April 20, 2022

Gareth Reece
Senior Plans Examiner
City of Mercer Island Community Planning and Development

RE: Permit 2109-150 Correction Comment Responses
Site Address: 9611 SE 72nd Street

A211

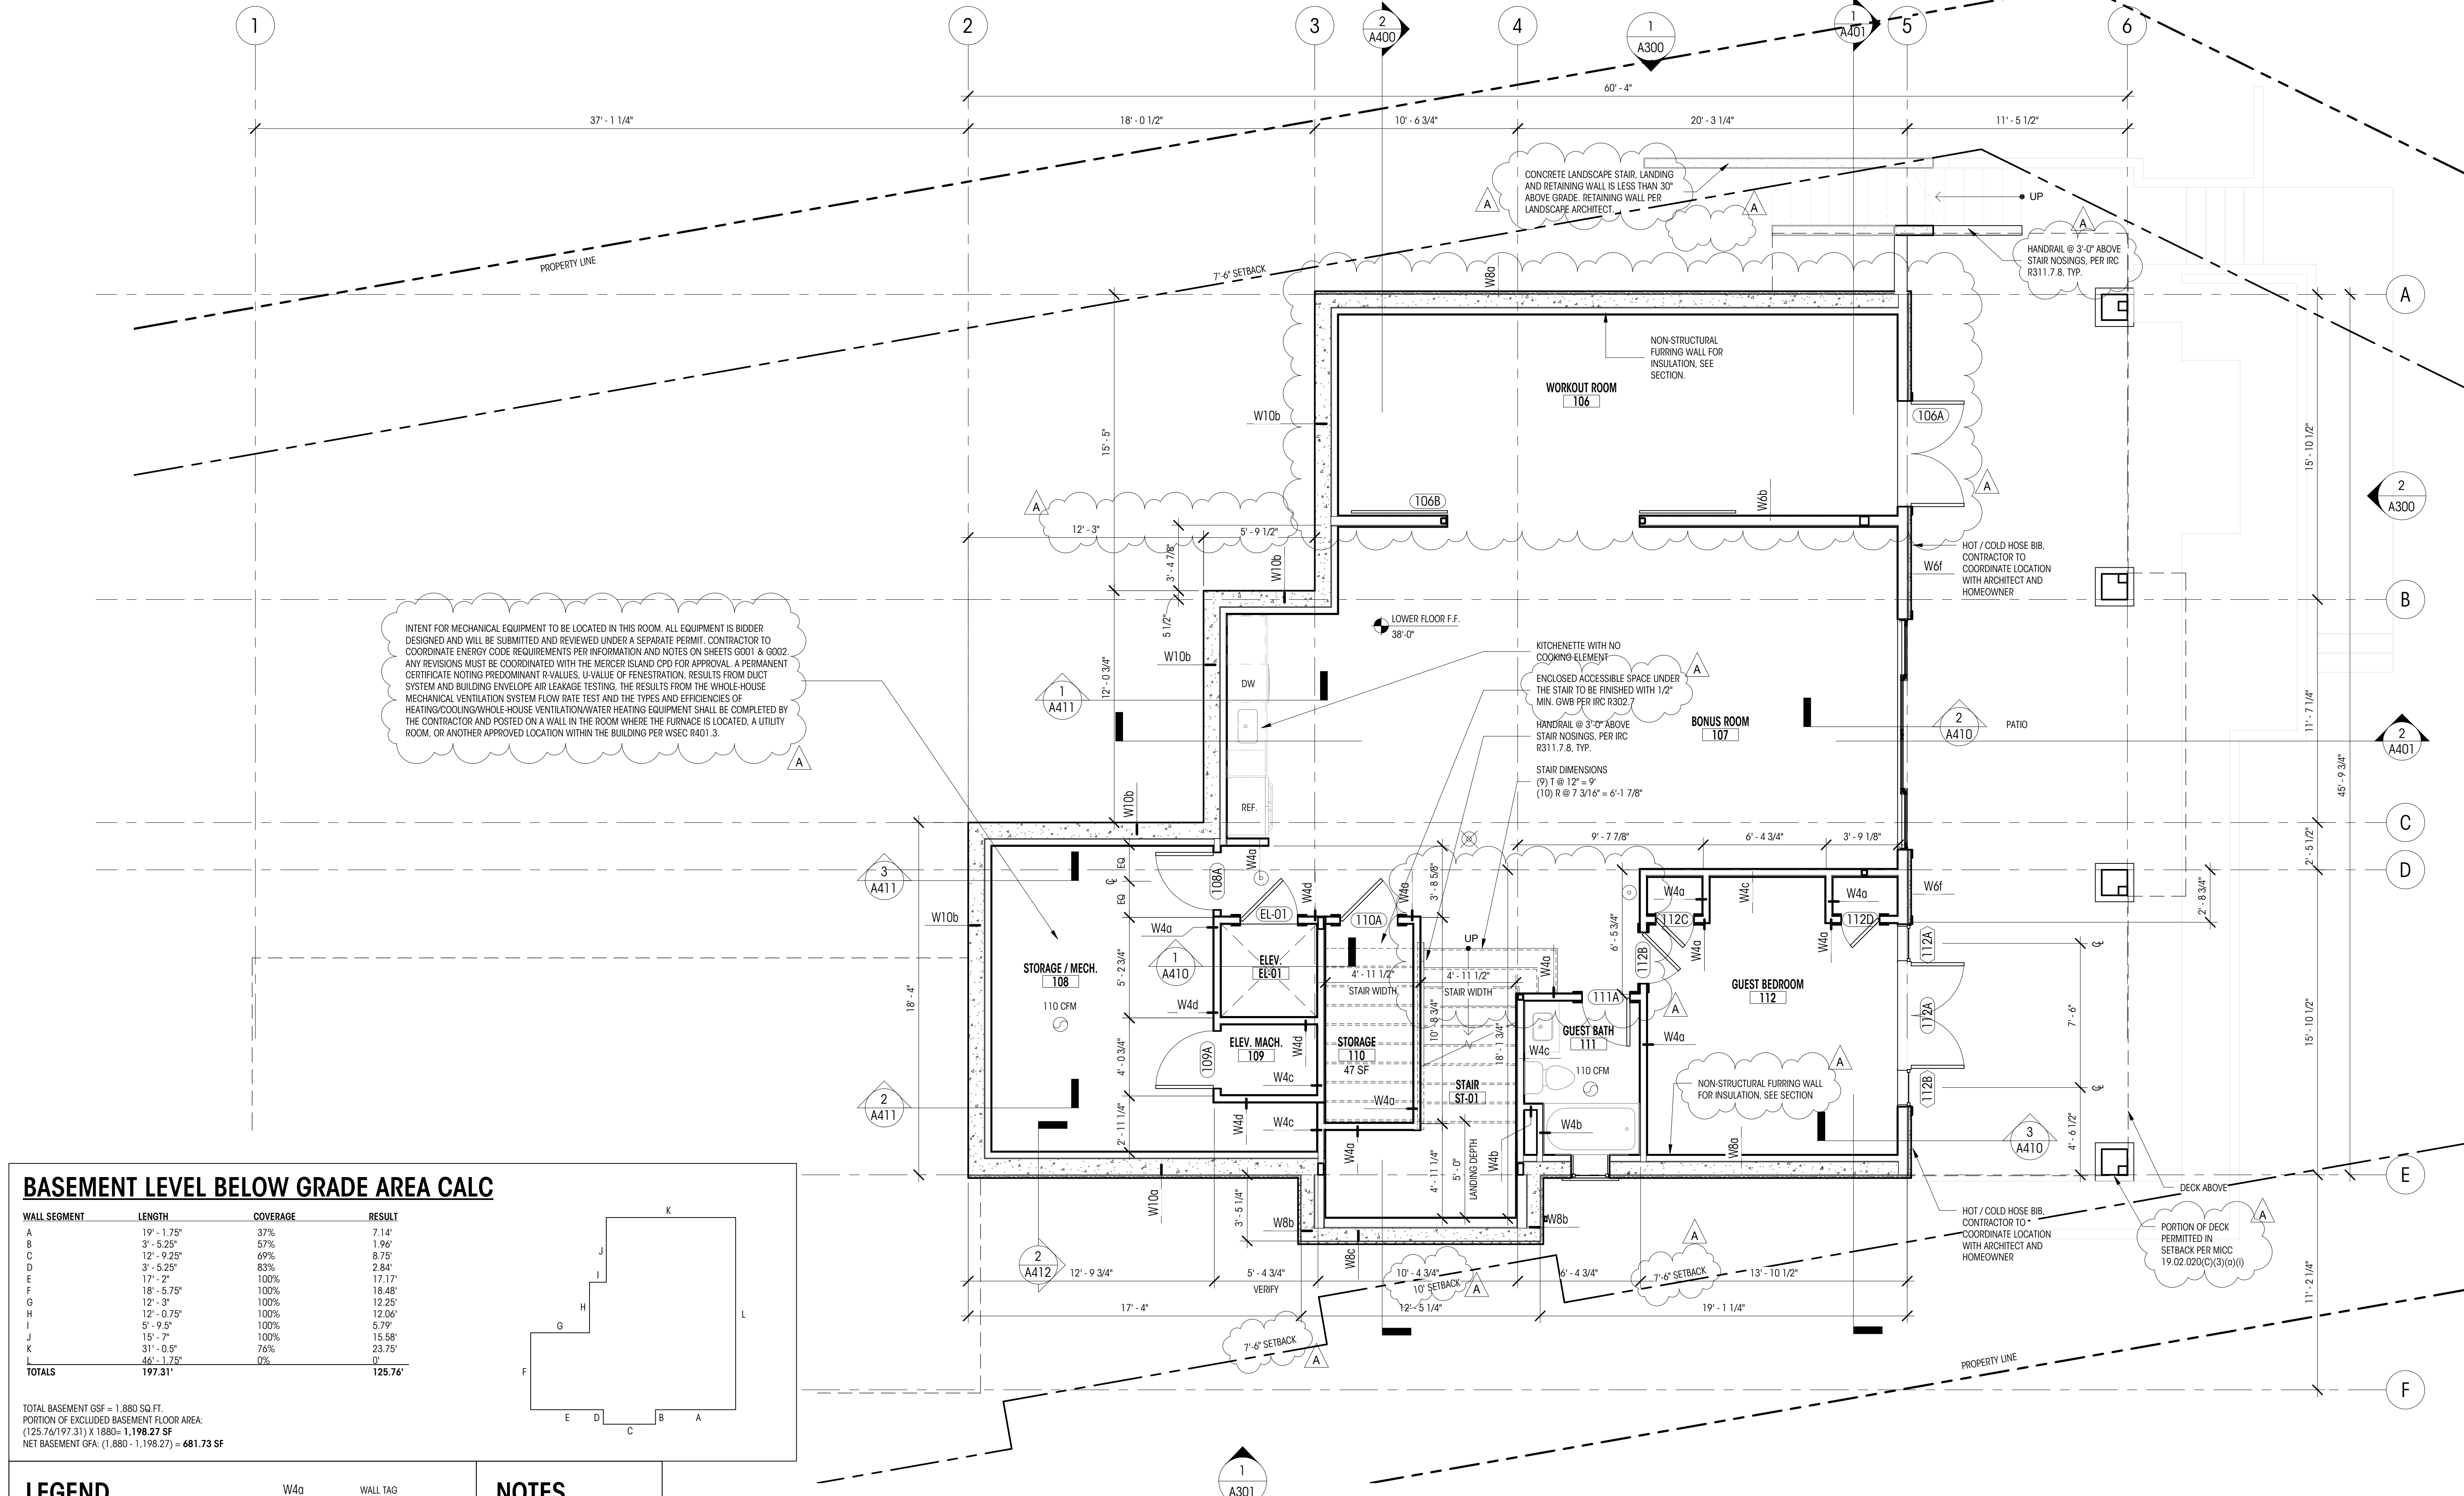
3. Enclosed accessible space under stairs must have walls, under-stair surfaces, and any soffits protected on the enclosed side with 1/2" GWB per IRC R302.7. Address this on the drawings.

- 9. A certificate is required to be posted on a wall in the space where the furnace is located, a utility room, or on an electrical panel per WSEC R401.3 and include the following: predominate R-values, U-values of fenestration, results from duct system and building envelope air leakage testing, the results from the whole-house mechanical ventilation system flow rate test, and the types and efficiencies of heating/cooling/whole-house mechanical ventilation/water heating

equipment. Provide notes on the drawings to address this.

Response: This has been noted on sheet A211 and A400.

Response: A note has been added to sheet A211.

A214

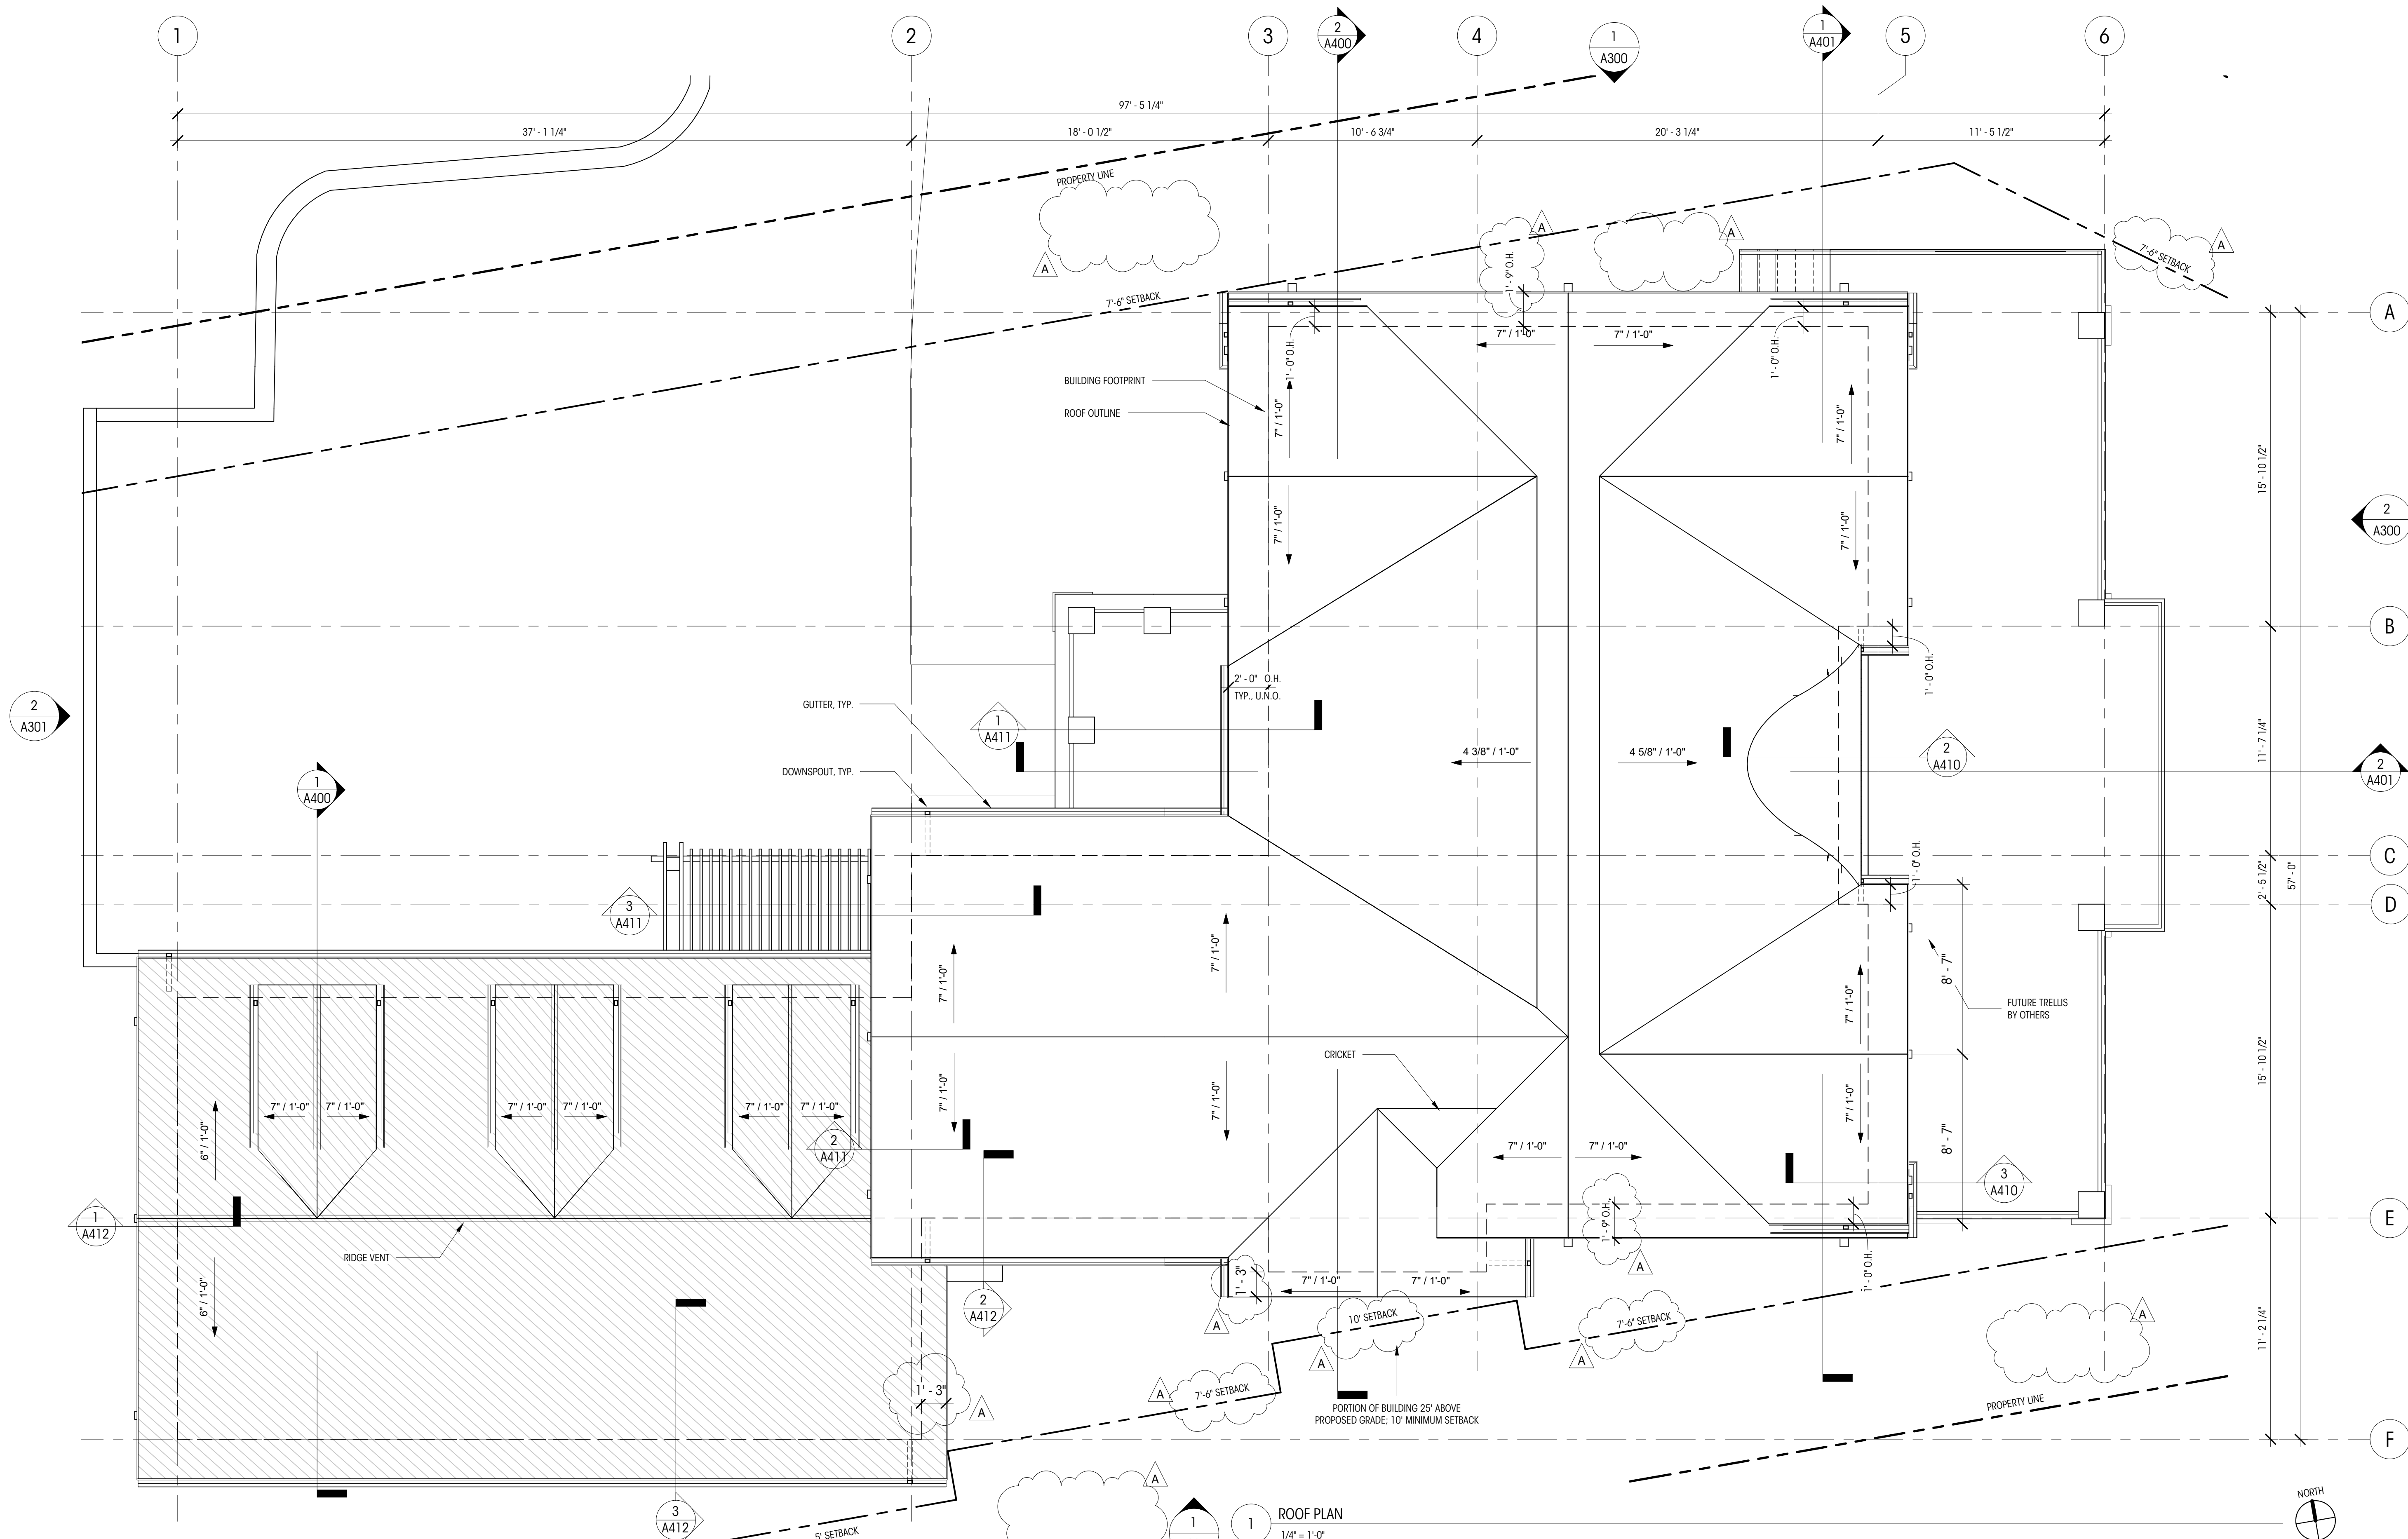
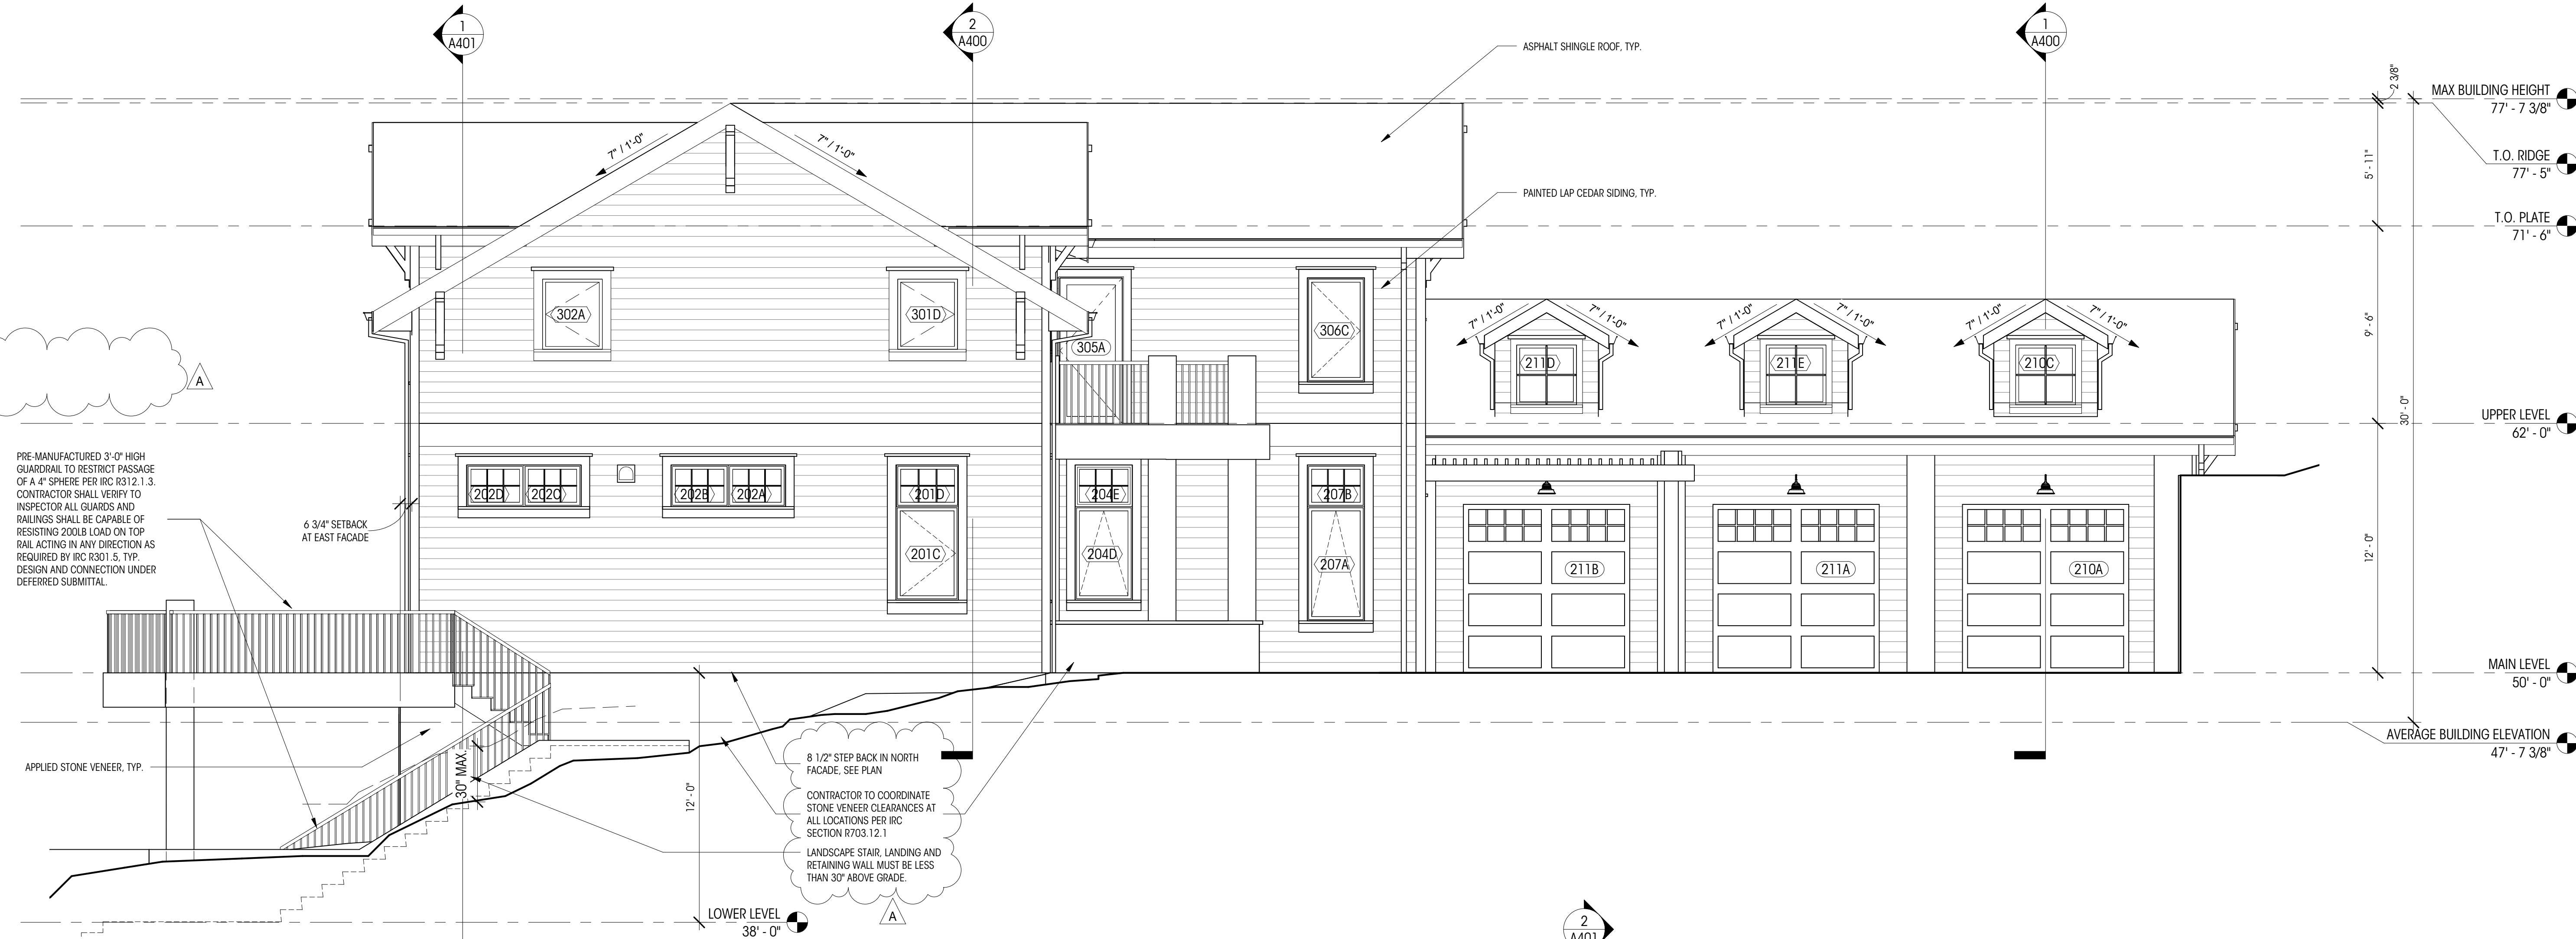
- b. If using spray-foam insulation, these areas would be unvented; revise roof ventilation evaluation on Sheet A214.

- c. The roof ventilation calculations on Sheet A214 should clarify the ventilation provided at roof eaves at the vented roof areas and some graphic should be provided differentiating the vented and unvented locations.

- d. The roof ventilation calculations on Sheet A214 should evaluate the net free ventilation area provided at roof eaves. The 2" diameter ventilation holes should be specified per eave block, not per l.f.

Response: See response to 12.a above. The roof ventilation calculation on sheet A214 has been updated to include the garage roof only.

Response: Graphic differentiation has been provided on sheet A214.

Response: The roof ventilation calculation on sheet A214 has been updated to address ventilation holes per framing bay.
